## DRAINAGE AND TRANSPORTATION INFORMATION SHEET

RE: Enterprise Car Rental, 5700 San Mateo Blvd NE, Traffic Circulation Plan for Building Permit F18D052

I am writing in response to the review comments dated September 23, 2022.

Sheet C-102

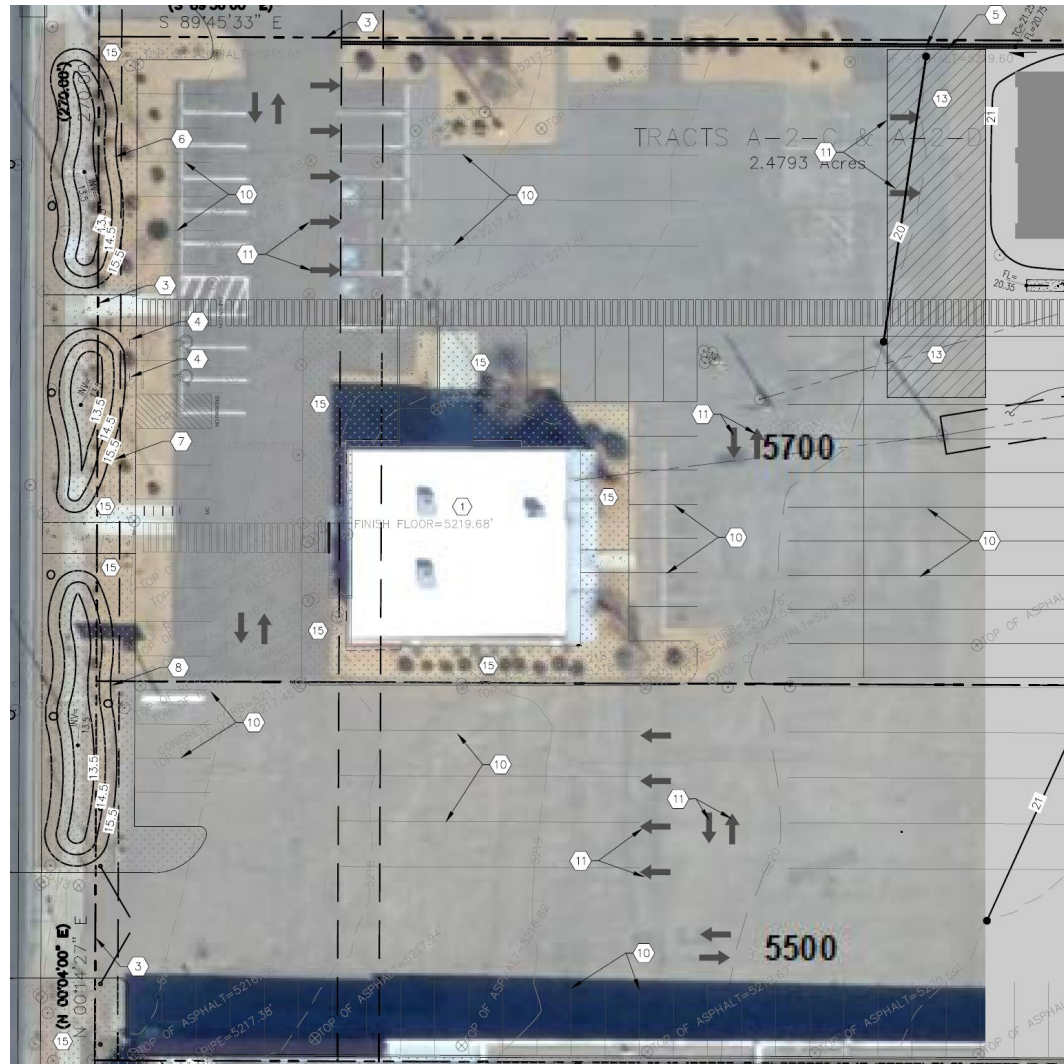
5. Also, please high light the shared access easement on the plat of topography exhibit. **Added, see sheet C-102.**
6. Traffic Studies: See the Traffic Impact Study (TIS) thresholds. In general, a minimum combination of 100 vehicles entering and exiting in the peak hour warrants a Traffic Impact Study. Visit with Traffic Engineer for determination and fill out a TIS Form that states whether one is warranted. In some cases a trip generation may be request for determination (Contact Matt Grush: [mgrush@cabq.gov](mailto:mgrush@cabq.gov)) **Not required per Matt Grush, see attached letter.**

DRAWING TITLE		
SITE PLAN - TCL		
	DESIGNED	PROJECT NO
	DRAWN	SCALE
	CHECKED	DRAWING NO
	REVIEWED	A-100
	DATE 03/22/2022

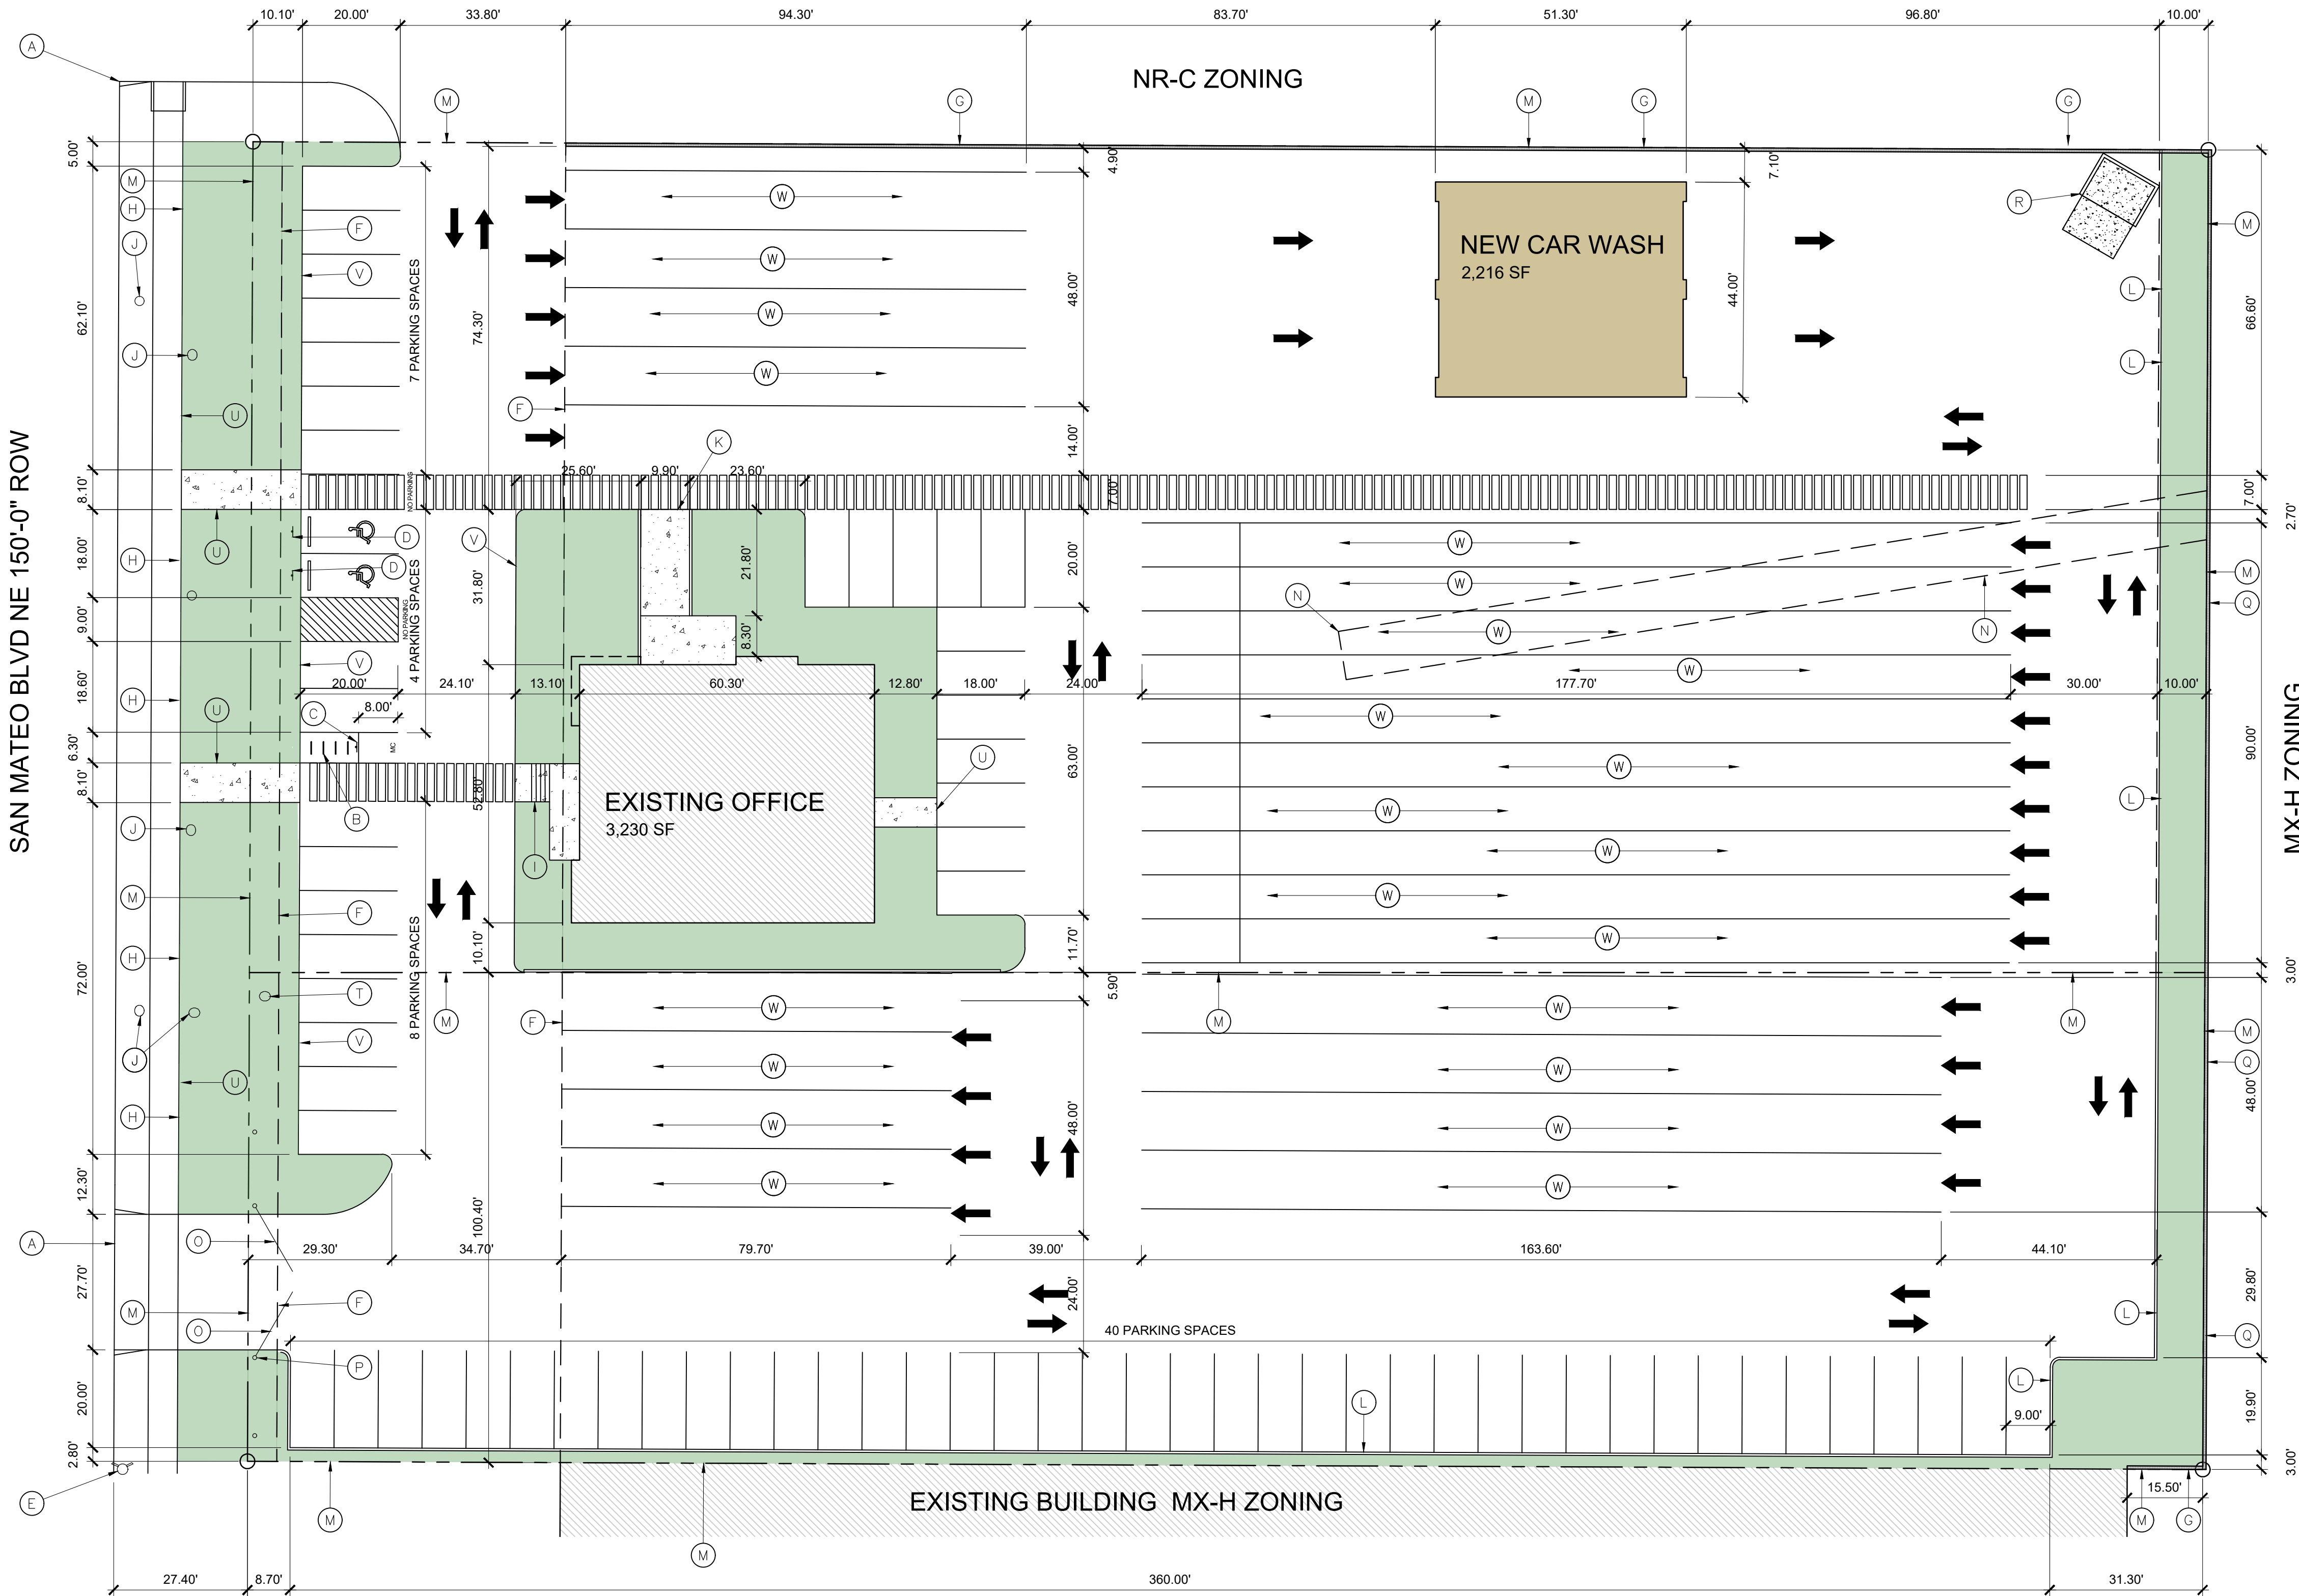
1. Driveways entrances off San Mateo Blvd. need to be updated to current ADA std. or Curb Return is recommended on Principal Arterial. San Mateo classified as Principal Arterial. **See keyed note Y "HC ramp COA standard detail 2425B".**

4. Per IDO Required Stacking space, you need to show minimum 3 vehicles stacking spaces in the car wash lanes. **There are 4 lanes that are 83.70' long for stacking in front of the private car wash.**

C5 HC PAVEMENT MARKING

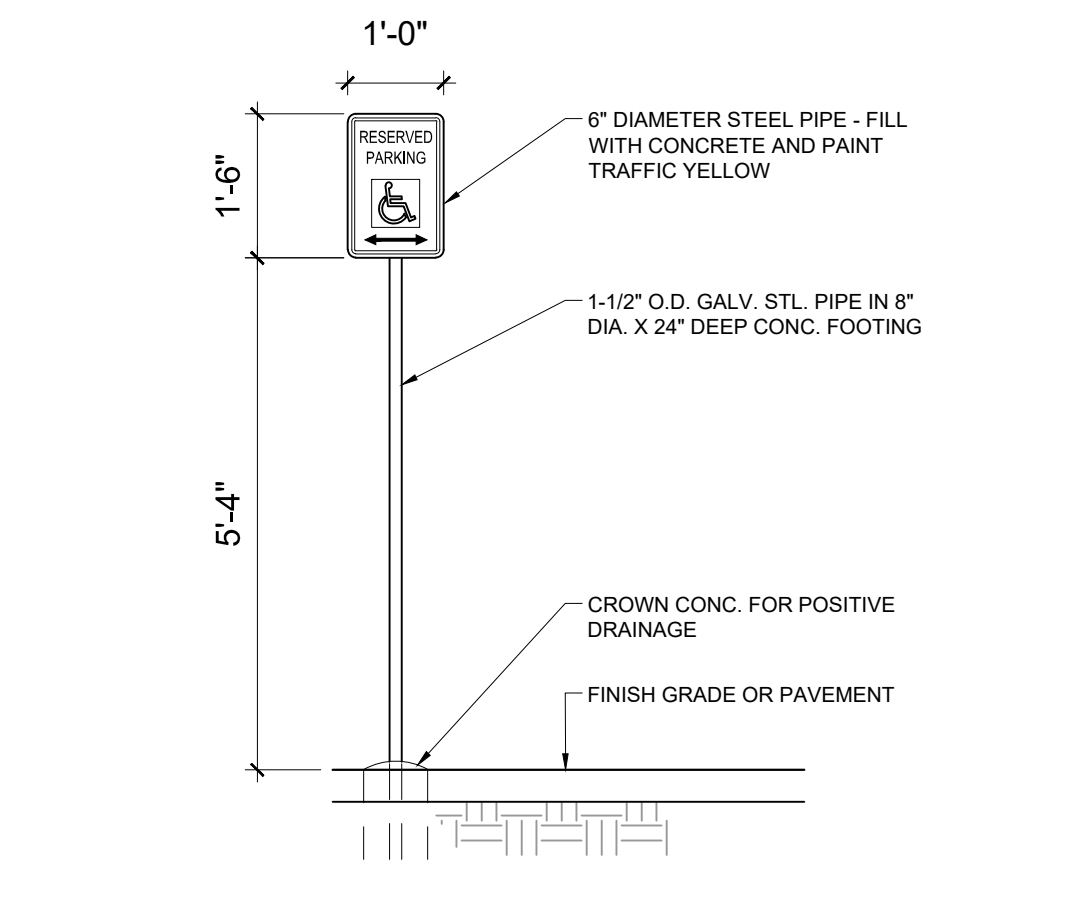
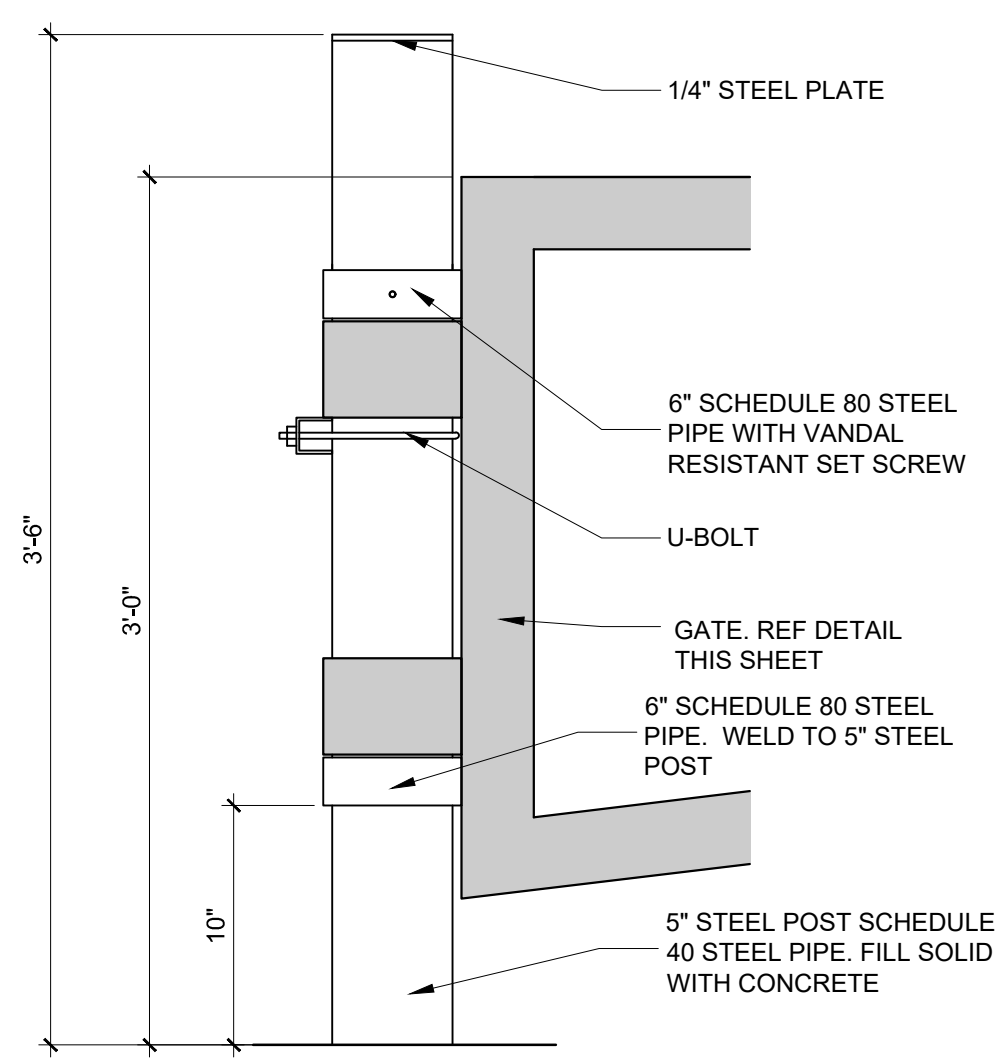
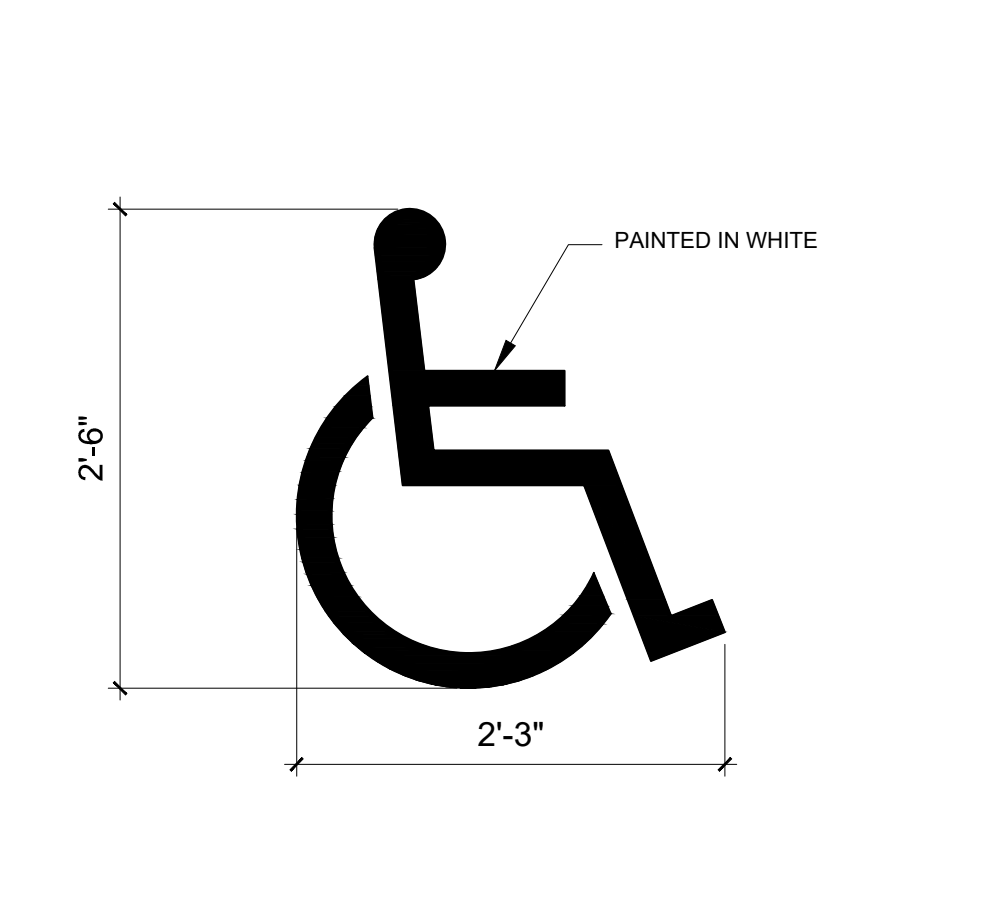
2. Provide details for the interior existing ADA ramp, to make sure it is ADA compliance. **See detail B6 on Sheet A-501.**
3. Please provide details for all the proposed signs and pavement markings. **Reference details on TCL sheet and sheet A-501.**
